From: Laura Gibbons
Sent: 17 April 2019 12:25
To: Planning.Responses
Cc: Michael Eastham
Subject: RE: Planning Consultation on: FP/85/19/DOC

Engineers Comments Regarding Condition 5

APPLICATION **FP/85/19/DOC**
NO:
Registered: 12th April

2019
Site Address: Felpham Communtiy Hall Meaden Way Felpham
Grid Reference: 495501 101158
Description of Works: Approval of details reserved by condition imposed under ref FP/166/09/ relating to Condition No. 2 materials & finishes, No. 3 NEAP, ball stop fencing & hardsurfacing and No. 5 foul & surface water sewerage.

A	11/12/14	Amended to suit correct layout.	HJS
REV. No.	DATE	DESCRIPTION	INITIALS
Client	AAP Architecture		
Project	Community Centre, Felpham, West Sussex		
Title	Engineering Details		
Scale	1:200@A2	Date	Jan 14
Checked	HJS	Drawn	HJS
Drawing No.	4866:01	Rev	A

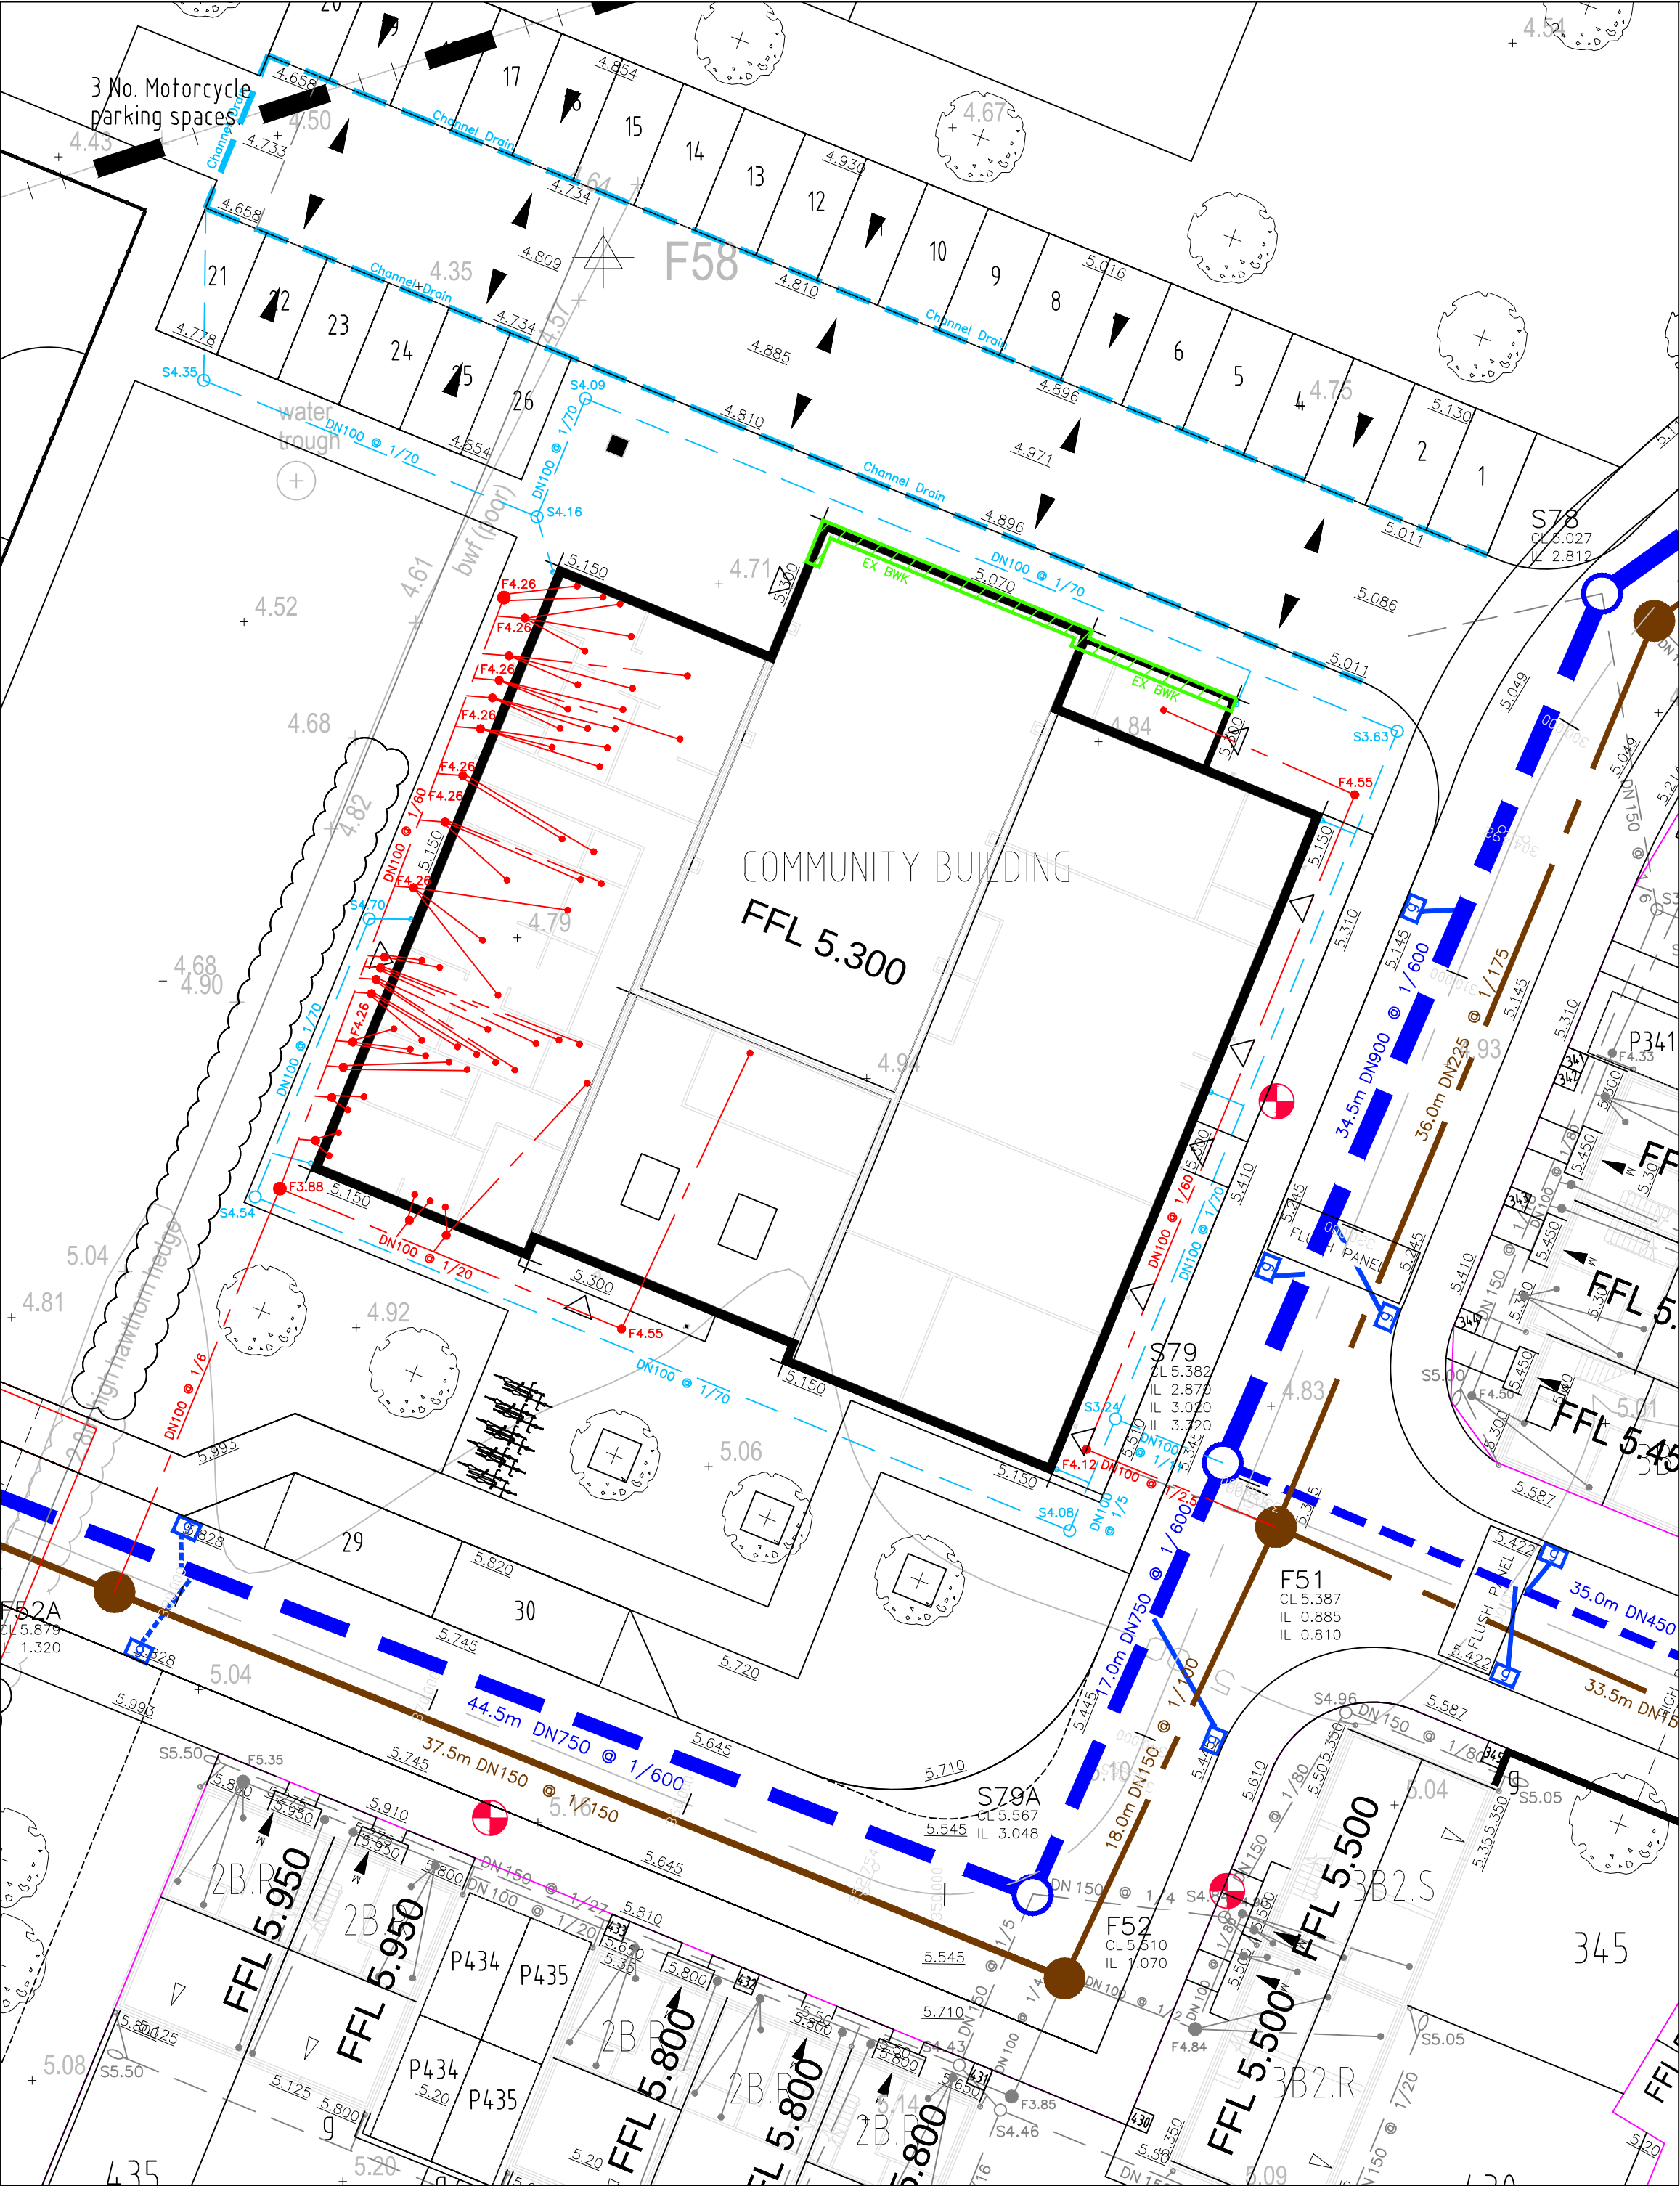
Please provide calculations based upon as built survey which demonstrate that the surface water drainage is adequate.
